**North Byron Parklands wastewater investigation submission from BVM / W&A –
revised commentary after reviewing receipt of further submissions from 25 Oct 2018**

GHD has been engaged by the Department of Environment and Planning (DPE) to undertake a third party review of the wastewater treatment and onsite irrigation scheme proposed for the continuation and expansion of the North Byron Parklands (NBP) cultural events site. GHD has provided a number of sequential reviews and comments related to the Wastewater Assessment (as prepared by Whitehead and Associates Pty Ltd (W&A), July 2018). In response to GHD's last round of comments on the Revised Wastewater Assessment (GHD, September 2018), W&A responded with a further letter report providing comments on some of the items raised by GHD. The DPE subsequently requested that GHD consider the latest rounds of comments provided by W&A (3 October 2018) with the aim of:

Graph 5: Schematic of NBP OSMS Treatment System for Stage 3

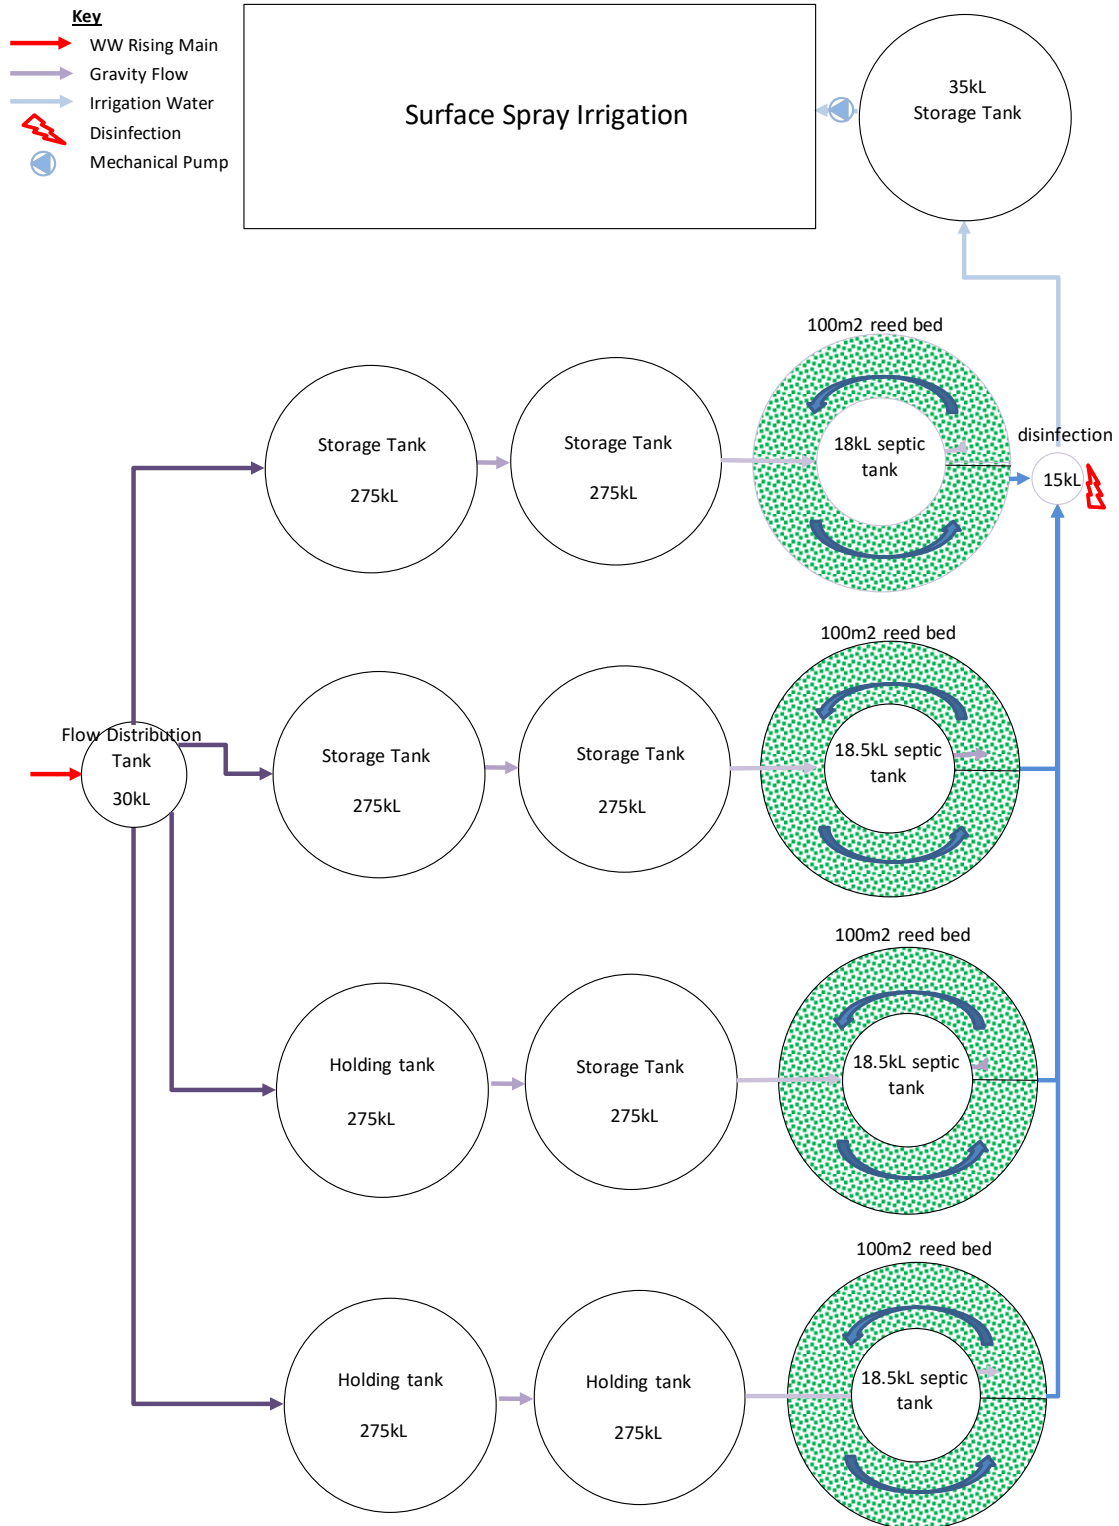
The overall system is potentially suitable for the stated effluent volume, and it is noted that a revision of proposed system (incorporating increase of size of reed bed system from 467 m² to 2,100 m²) might be suitable for appropriate treatment of the wastewater for irrigation.

In the submission form W&A (23 October 2018) there has also been some additional processing / treatment has been proposed to achieve further nitrogen reduction. While there are likely benefits and contaminants will likely be reduced, GHD still considers the target effluent quality (from inflow TN > 300 mg/L) to be ambitious. However, in the interest of expediting the approvals process, rather than debating the likely final water quality further, GHD has made recommendations for conditions of approval to mitigate risks to the environment in the event that the final wastewater does not meet the standard predicted by W&A. These recommended conditions of approval specifically relate to the need to verify the quality of the wastewater on an ongoing basis. It will also be important for the Proponent to undertake some further modelling to account for the irrigation area and irrigation practices required to dispose of the recycled water safely, in the event the actual recycled water is closer to a 'worst case scenario' (see Section 4).

Drawn:	Reviewed:	Approved:	Date:	Scale: 1:10,000 Approx @ A3	
HM	SD	SD	05/10/17	Job No: 1912	Sheet: 1 of 1
All units in m unless otherwise specified				Drawing No: Figure 5	Revision No: 1

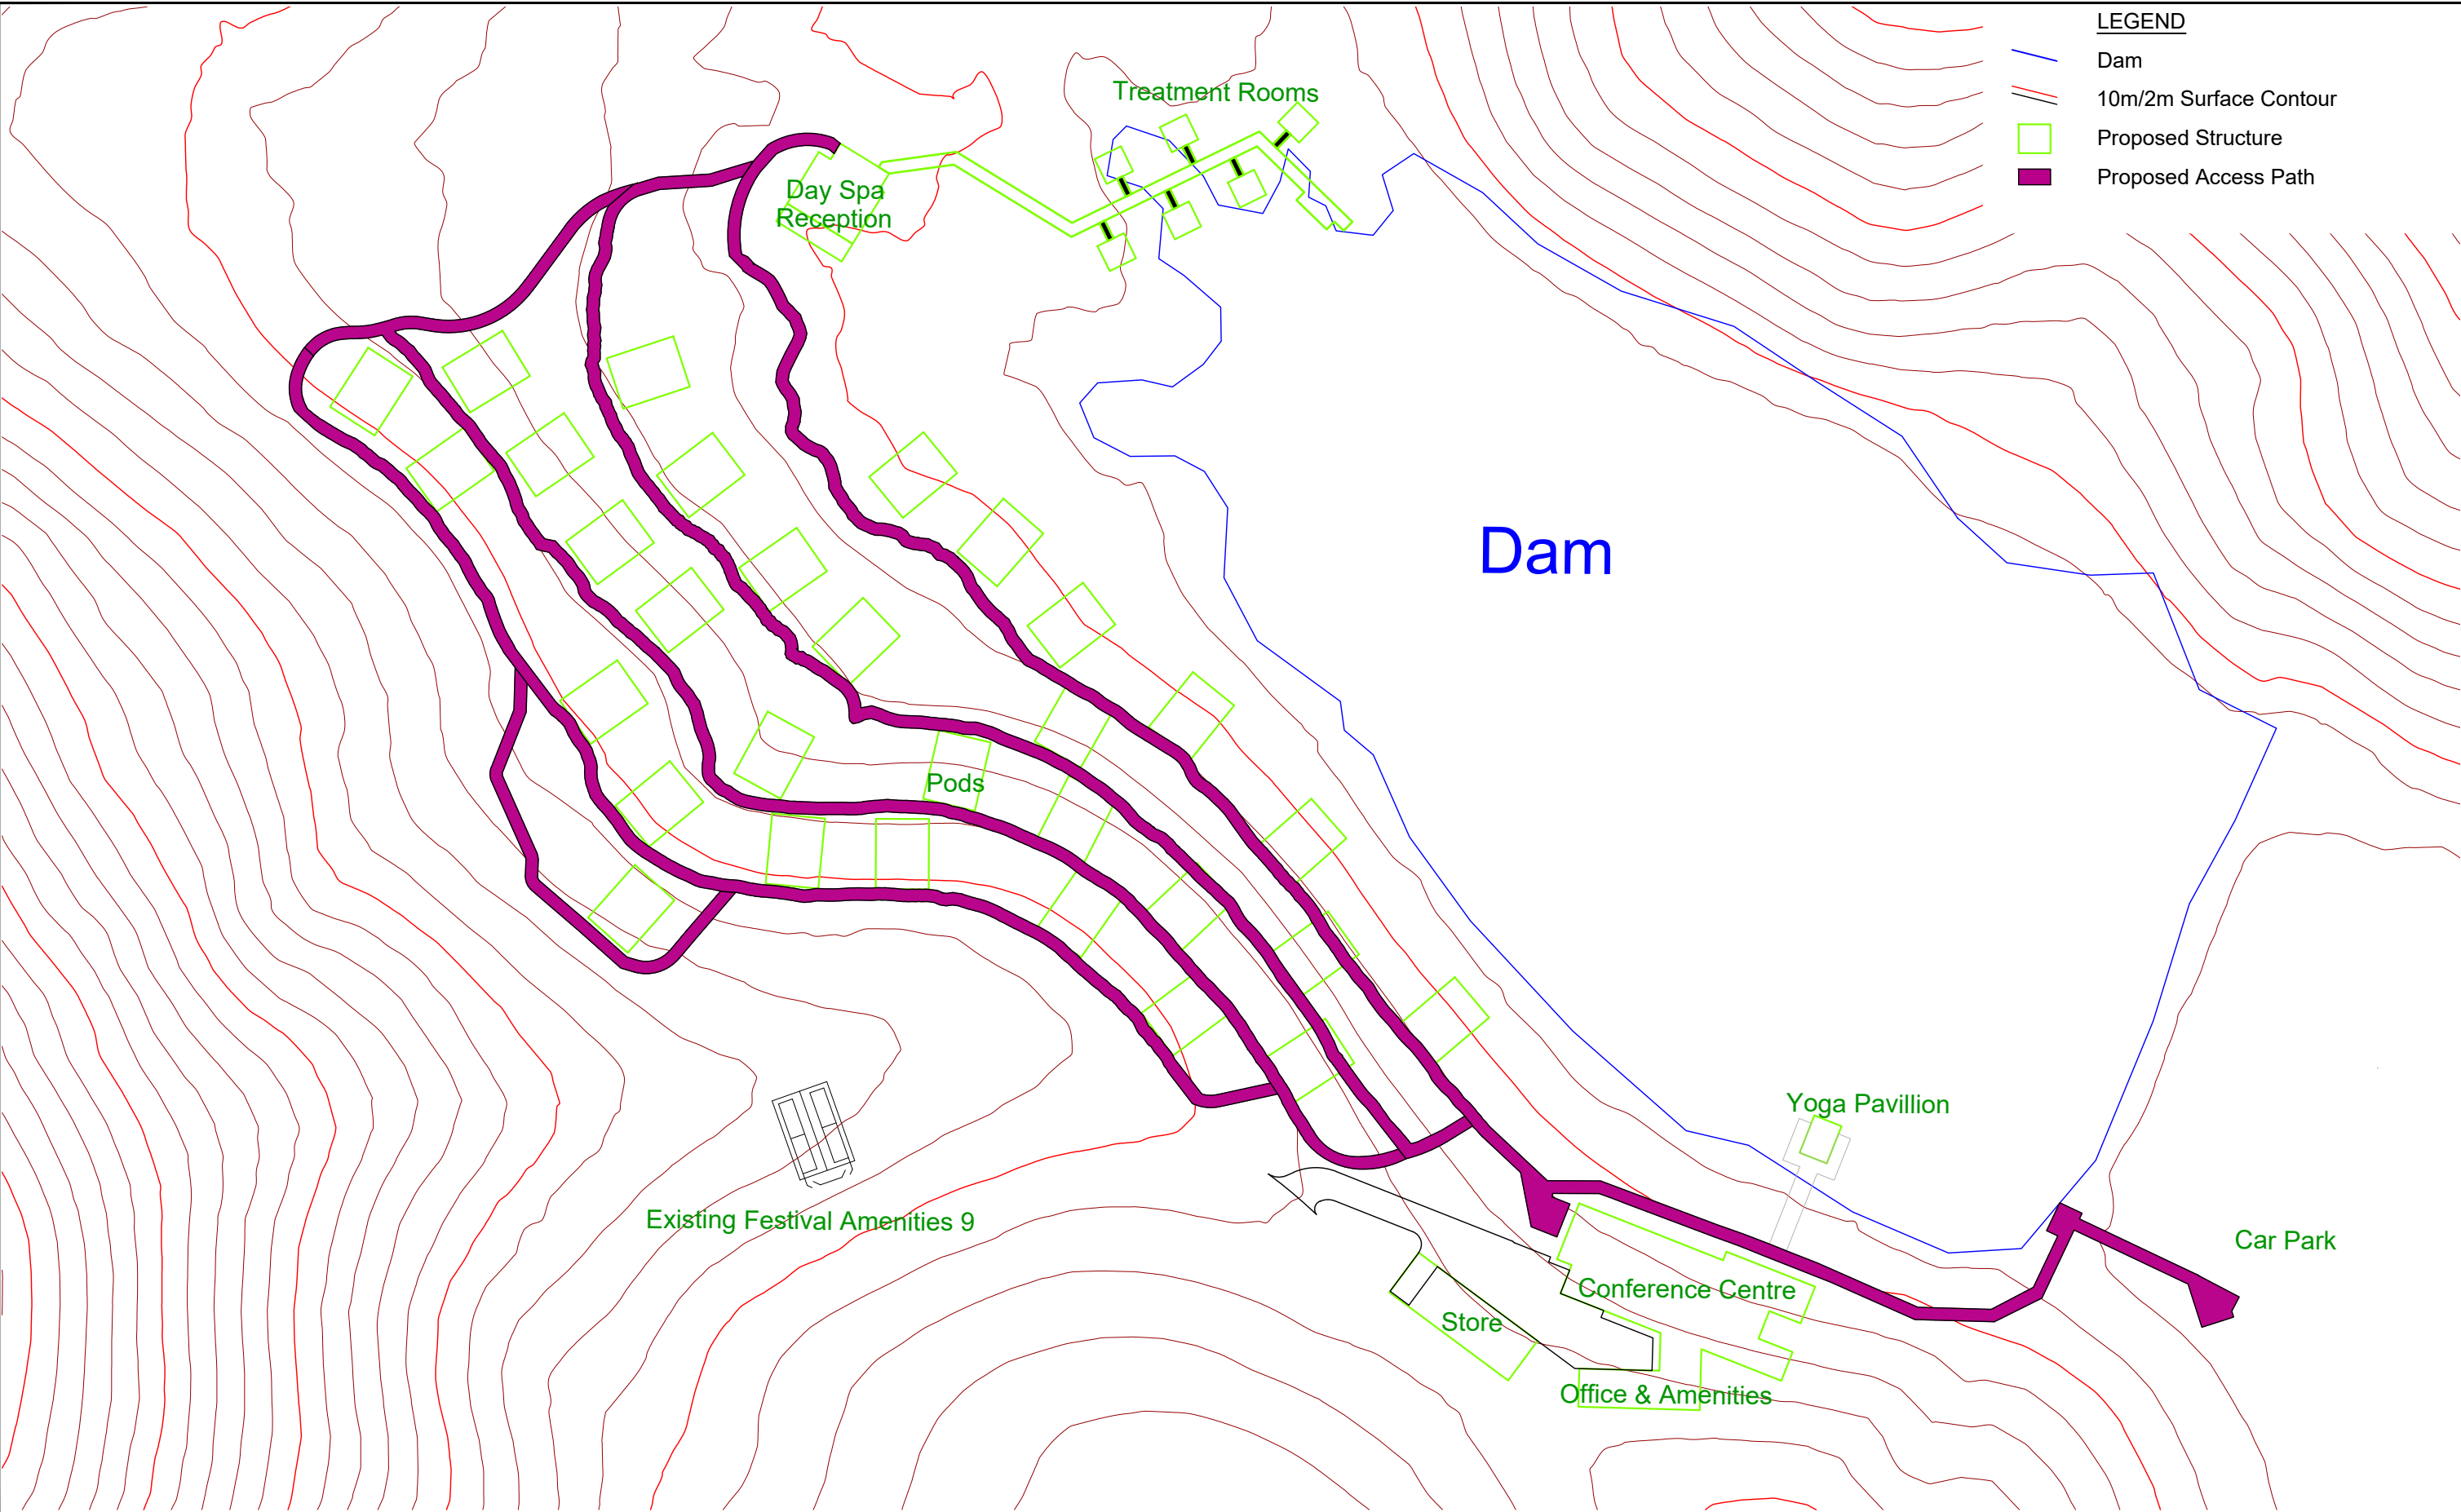
- The areas in the south of the site are heavily vegetated and not suited for the irrigation approach outlined in the Wastewater Assessment and thus are not preferred irrigation areas.
- Given the mapped extent of 1:20 and 1:100 flood levels, periodic flooding of areas in the south of EMA2 (as mapped in Figure 5 of the Revised Wastewater Assessment) means this area is not likely to be well suited for irrigation.
- W&A suggest in their latest response that the northern area is more desirable as the proponent also owns the farmland to the north and there are less sensitive receptors in this direction than to the south of the site.

- Specific, isolated areas have been selected for spray irrigation in the north-eastern corner of the site (these areas are cross-hatched black on figures in the Revised Wastewater Assessment). It is not made clear in available reports why these smaller areas within EMA2 are proposed as the preferred areas given that these areas have reported the shallowest groundwater and are at closer proximity to nearby offsite waterways than other parts of EMA2.

GHD recommends that the preferred irrigation area within EMA2 be reassessed and areas positioned further west around the middle portion of the camping area, nominally areas where groundwater is typically > 1 m below ground level. The nominated irrigation area should be re-sized to achieve an irrigation 'deficit' so that soils are always irrigated to less than available field capacity (readily available water) to further reduce the risk of drainage to underlying groundwater. A percentage 'deficit' (i.e., 85% of field capacity) can be built into the MEDLI model. The preferred irrigation method should be adapted if necessary to allow the selection of the most appropriate area for irrigation.
